**RE: TWEED VALLEY HOSPITAL STAGE 2 EIS RESPONSE TO SUBMISSIONS –
TRANSPORT AND TRAFFIC**

Bitzios Consulting Pty Ltd (Bitzios) has been engaged to prepare responses and provide further information to the Transport Planning and Traffic Engineering items of relevant Government agency responses for Stage 2 of the Tweed Valley Hospital EIS. This letter specifically responds to:

Project Name  
TWEED VALLEY HOSPITAL  
DEVELOPMENT, KINGSCLIFF,  
NSW  
Drawing Title  
CONCEPT INTERSECTION WORKS  
PLAN SHEET 1 OF 2

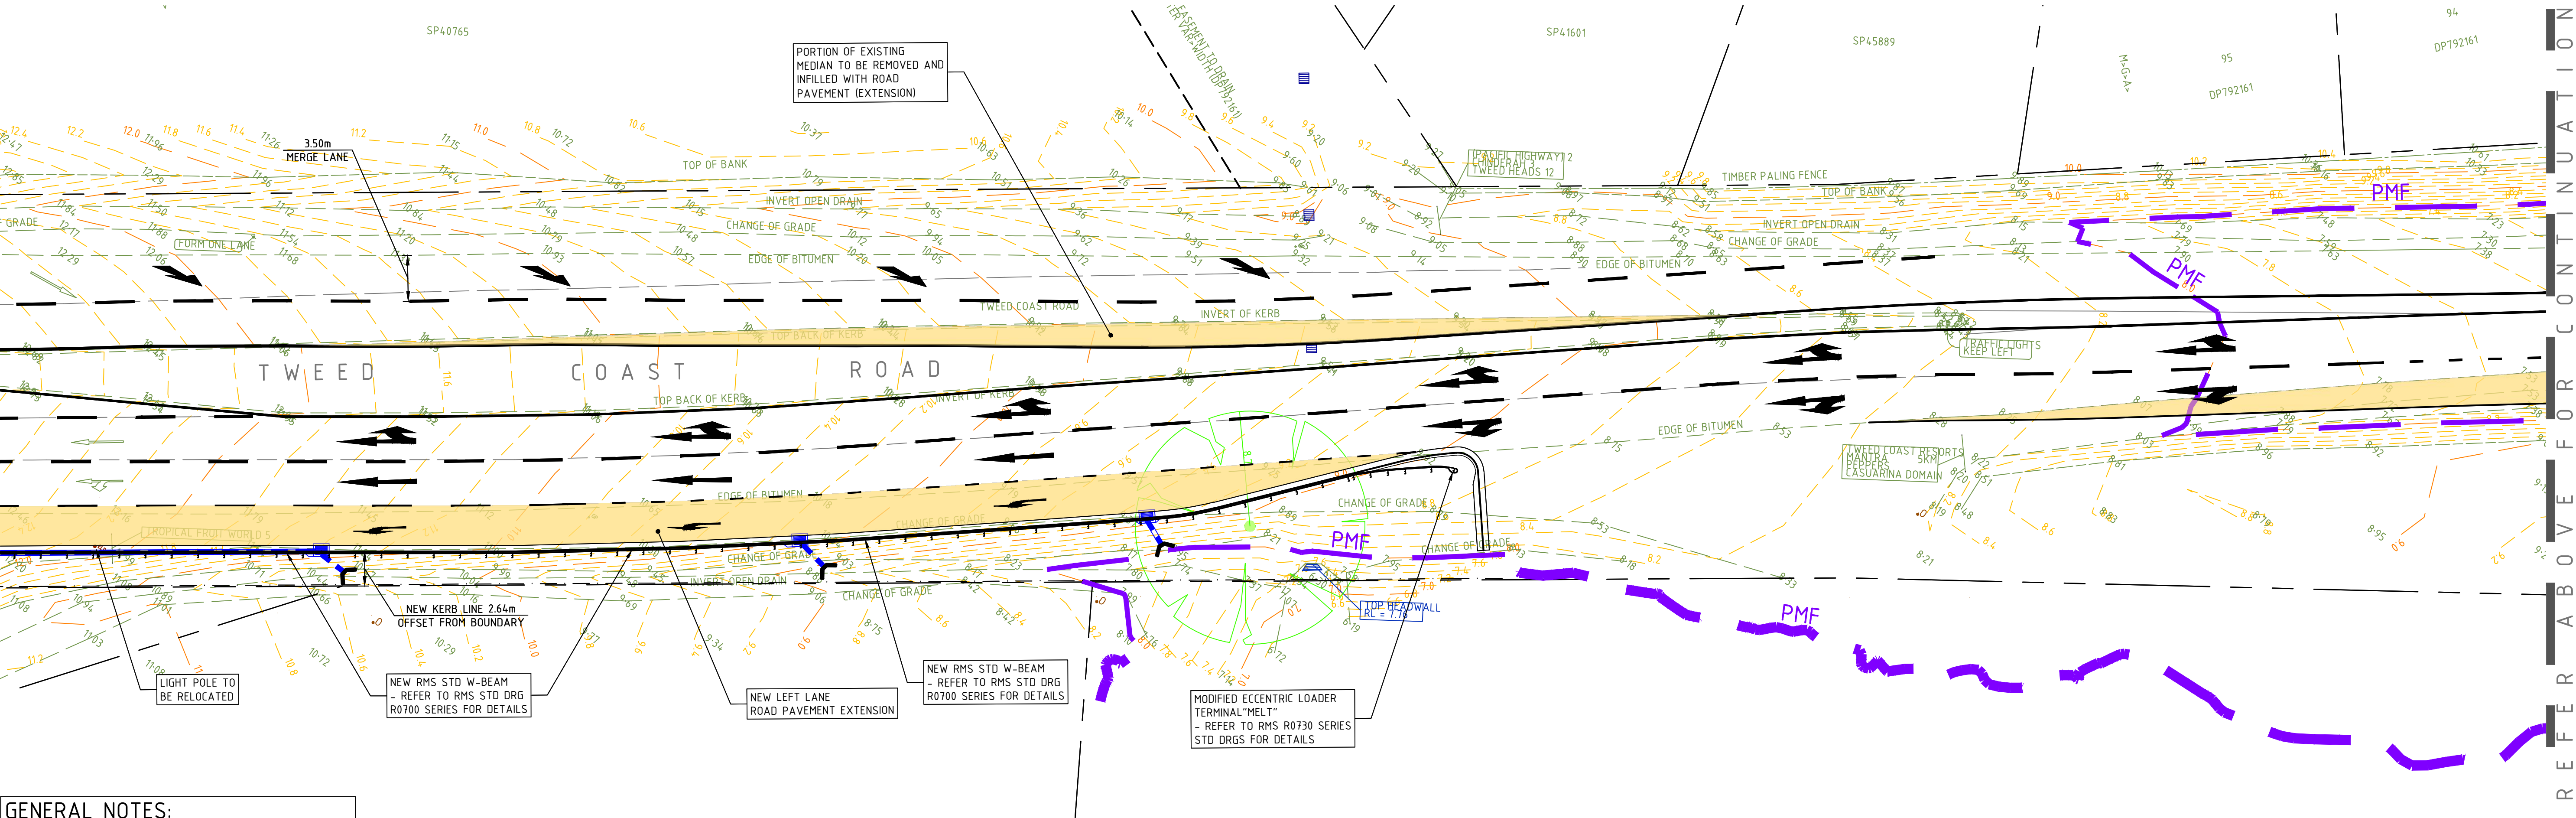
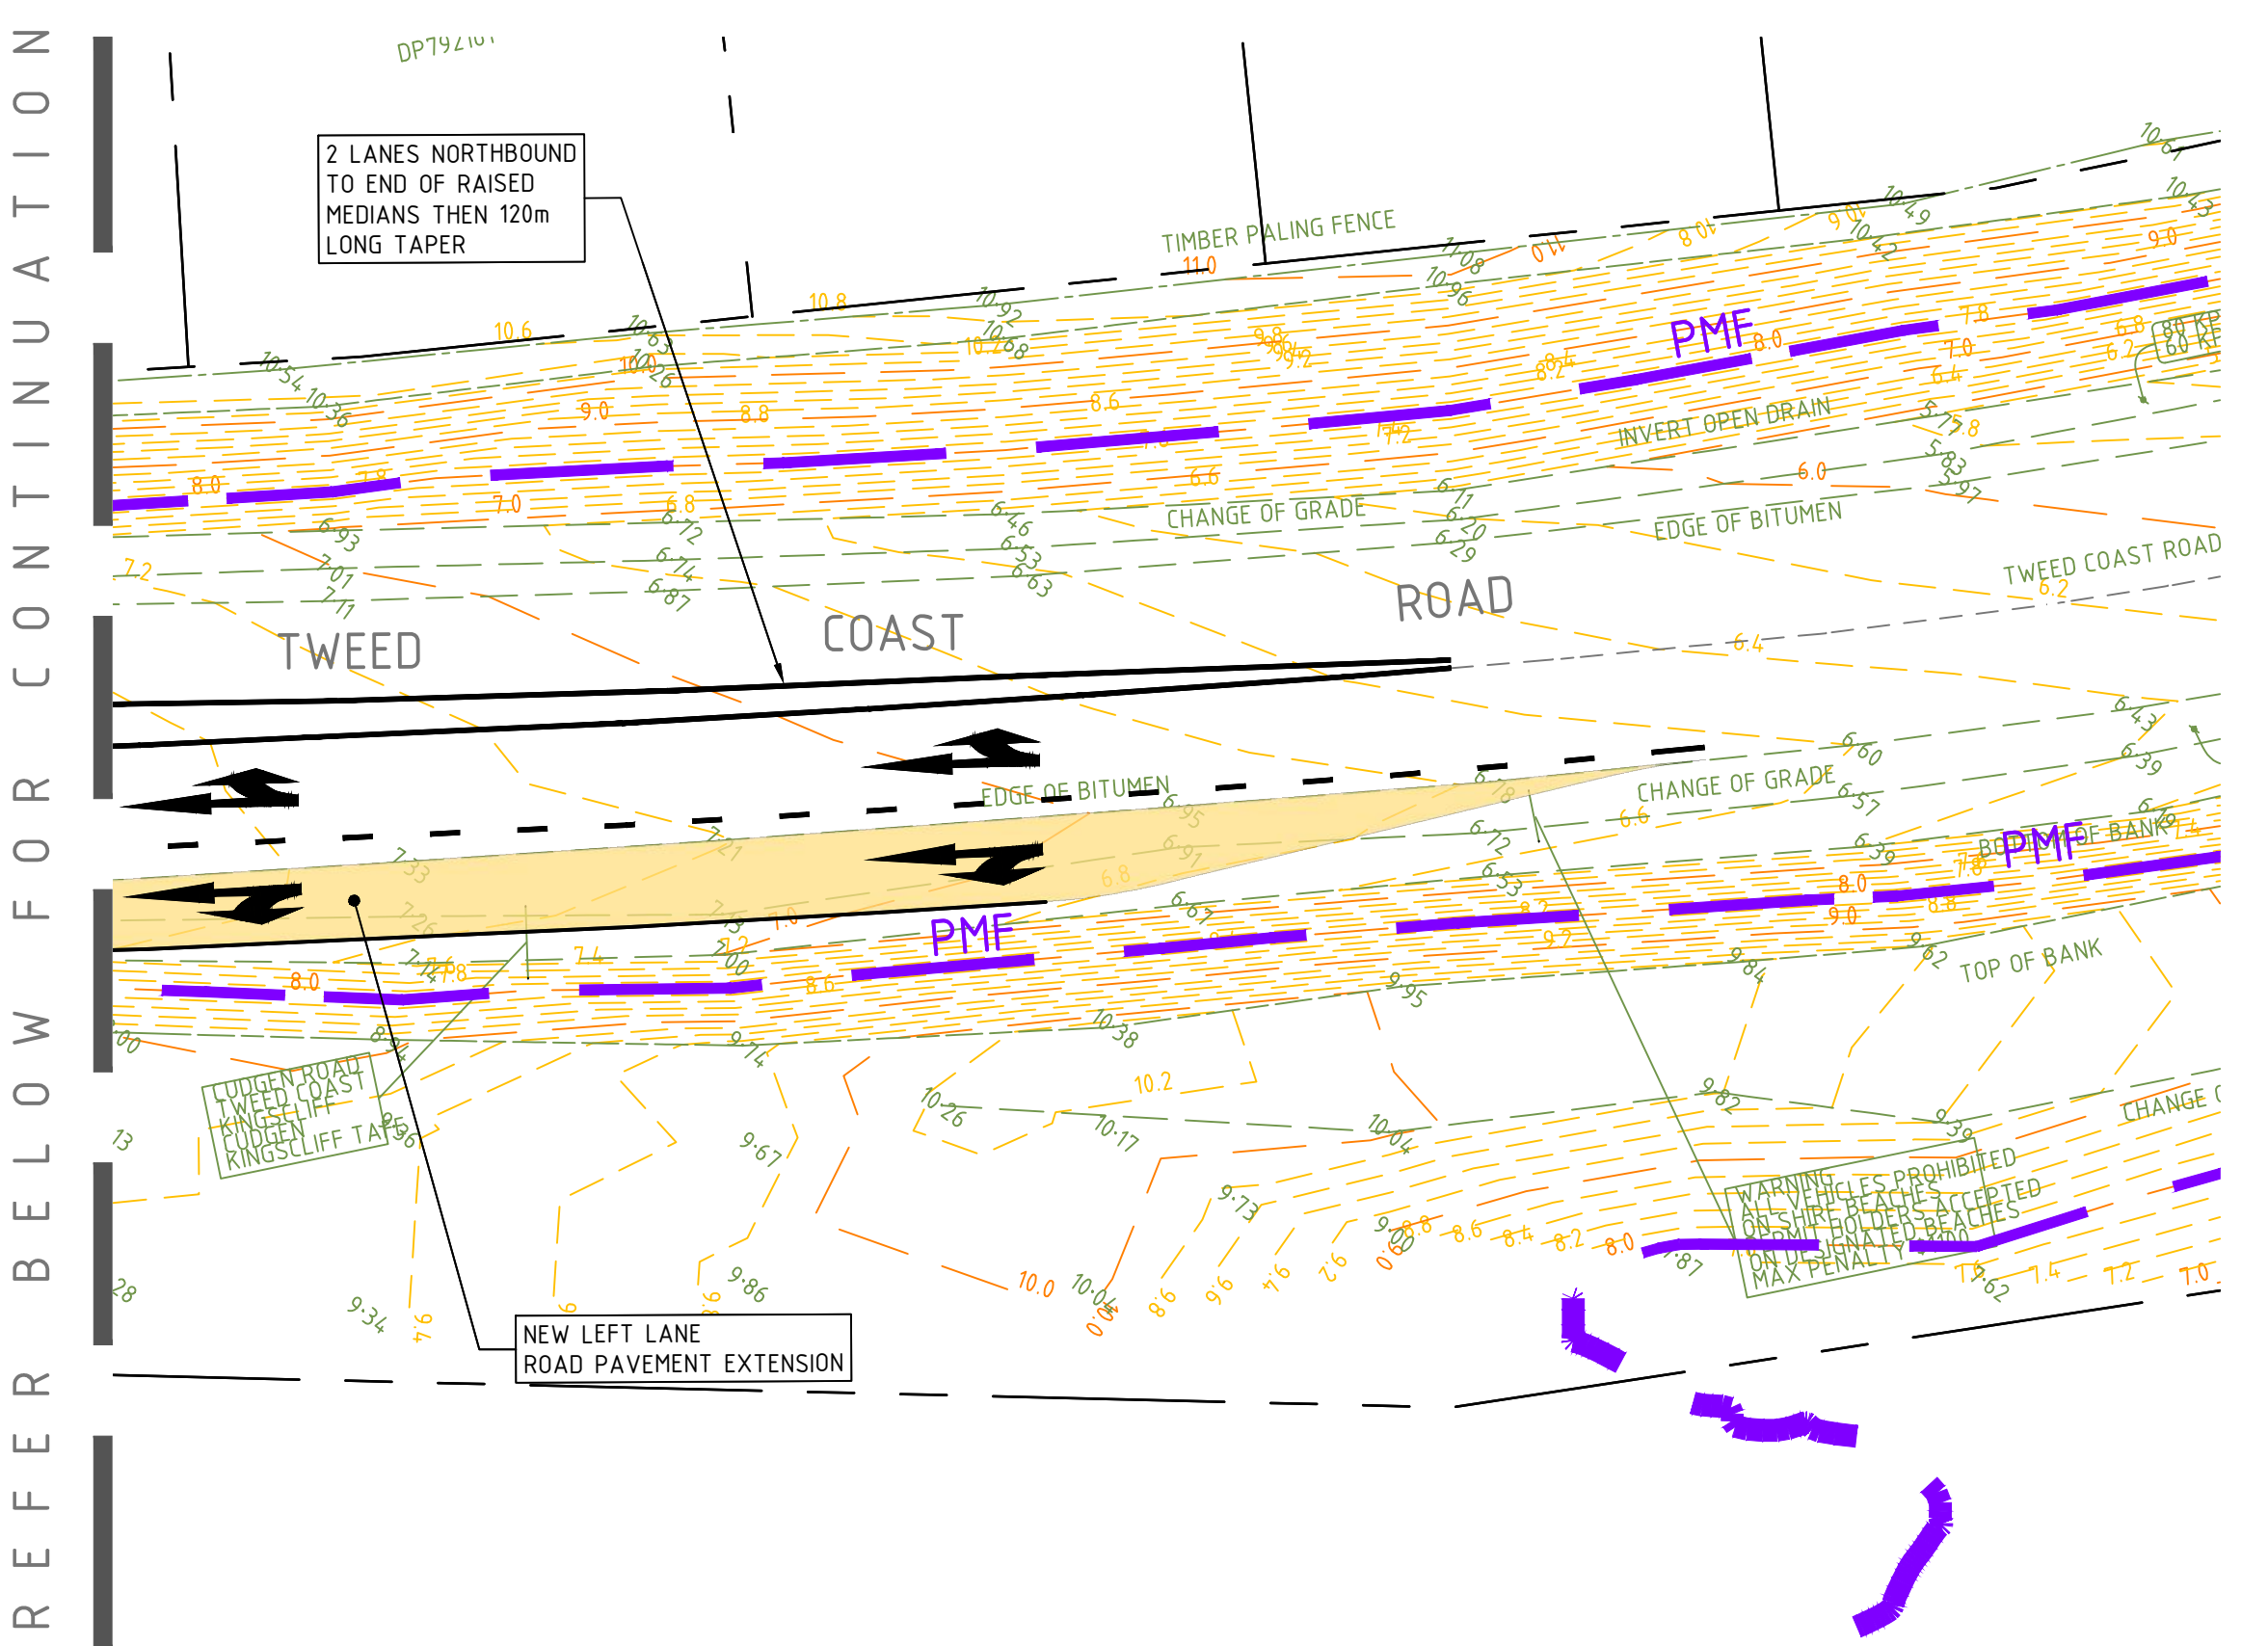
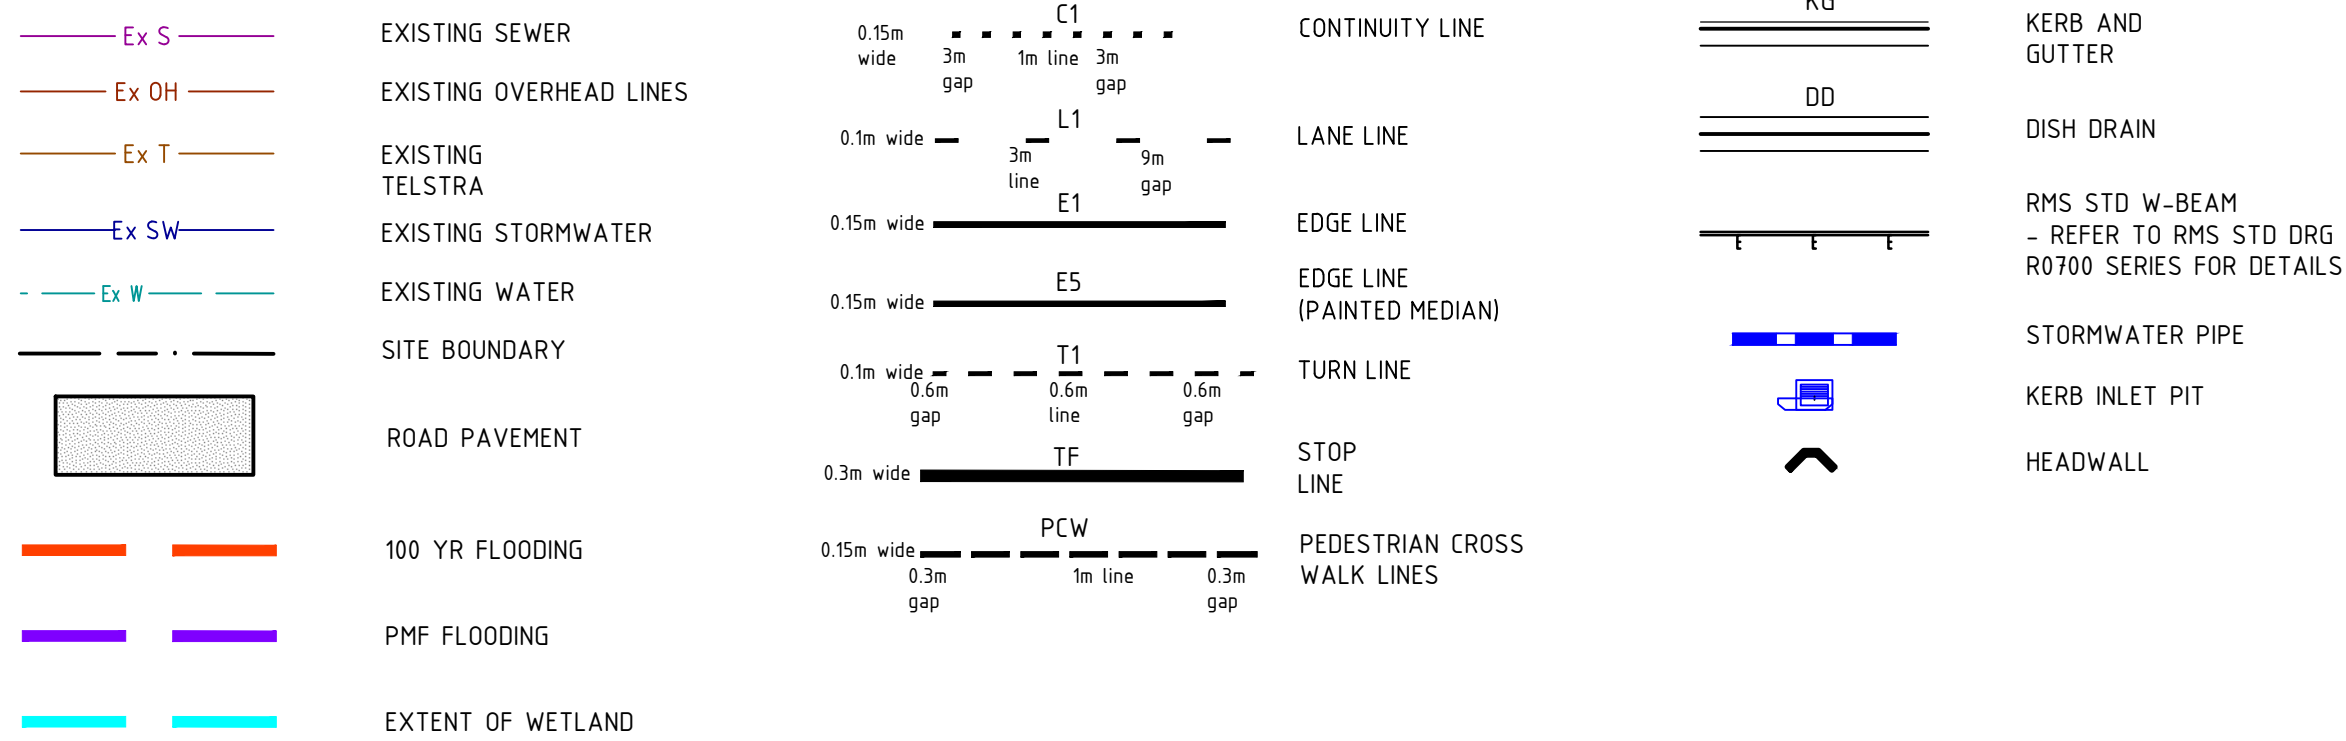
- Stage 1 consent condition B22 (c) requires plans for the upgrade for Tweed Coast Road/Cudgen Road intersection. The plans provided for stage 2 have no dimensions and should be updated to include the additional lengthening of the Tweed Coast Road north-bound right-turn bay, and left-turn deceleration lanes on Cudgen Road. No detailed plans were provided for the proposed traffic signals at the Hospital entrance.

- Modelling provided with the Stage 2 EIS has indicated that only 20m storage was required for the east-bound left-turn deceleration lane. This should be lengthened to provide 55m to cater for deceleration and queuing back from the hold line as only a single entry lane is provided for both left and right-turning entering traffic into the site. This change should also apply to the four other left-turn slip lanes (east-bound left-turn lane at Tweed Coast Road signals; and the three along the frontage of the site).

Updated plans have been prepared by Robert Bird Group (RBG) showing dimensions for all proposed intersection works (short lane lengths, lane widths etc.).

Provision of detailed design drawings is not considered warranted for the purpose of Development Approval. It is recommended that provision of detailed design drawings for the proposed upgrades at the Tweed Coast Road / Cudgen Road intersection and signalised Site access to Cudgen Road be conditioned to be provided as part of the approval.

SIDRA model results for the signalised Cudgen Road / Site access are presented in Section 5.4.4 of the TIA. The slip lane at the intersection is referred to in the results as Approach: *Southwest Cudgen Road (SW)* and OD Movement: *L2*. The maximum 95th percentile queue length modelled in all scenarios was 2.4m (i.e. less than one vehicle). While only a single entry is provided into the site, the only conflicting movement is the right-turn movement during C Phase. The left turn movement has priority due to the signal phasing at all other times, which is reflected in the low vehicle queues. The provision of a left slip lane (with a storage length of 20m) was incorporated in the design to maximise the efficiency of the intersection operations. The provision of short left-slip lanes is common design practice, including at other intersections in the Tweed Shire, such as:

The design is also constrained by the requirement to provide a 30m vegetated agricultural buffer between Cudgen Road and the main Hospital building. Any extension to the left-turn lane would reduce this buffer below acceptable levels.

Extending the left slip into the site is onerous given the expected queue length, impacts to the vegetation buffer requirements for the site and is inconsistent with numerous similar signalised intersection designs across the Tweed shire.
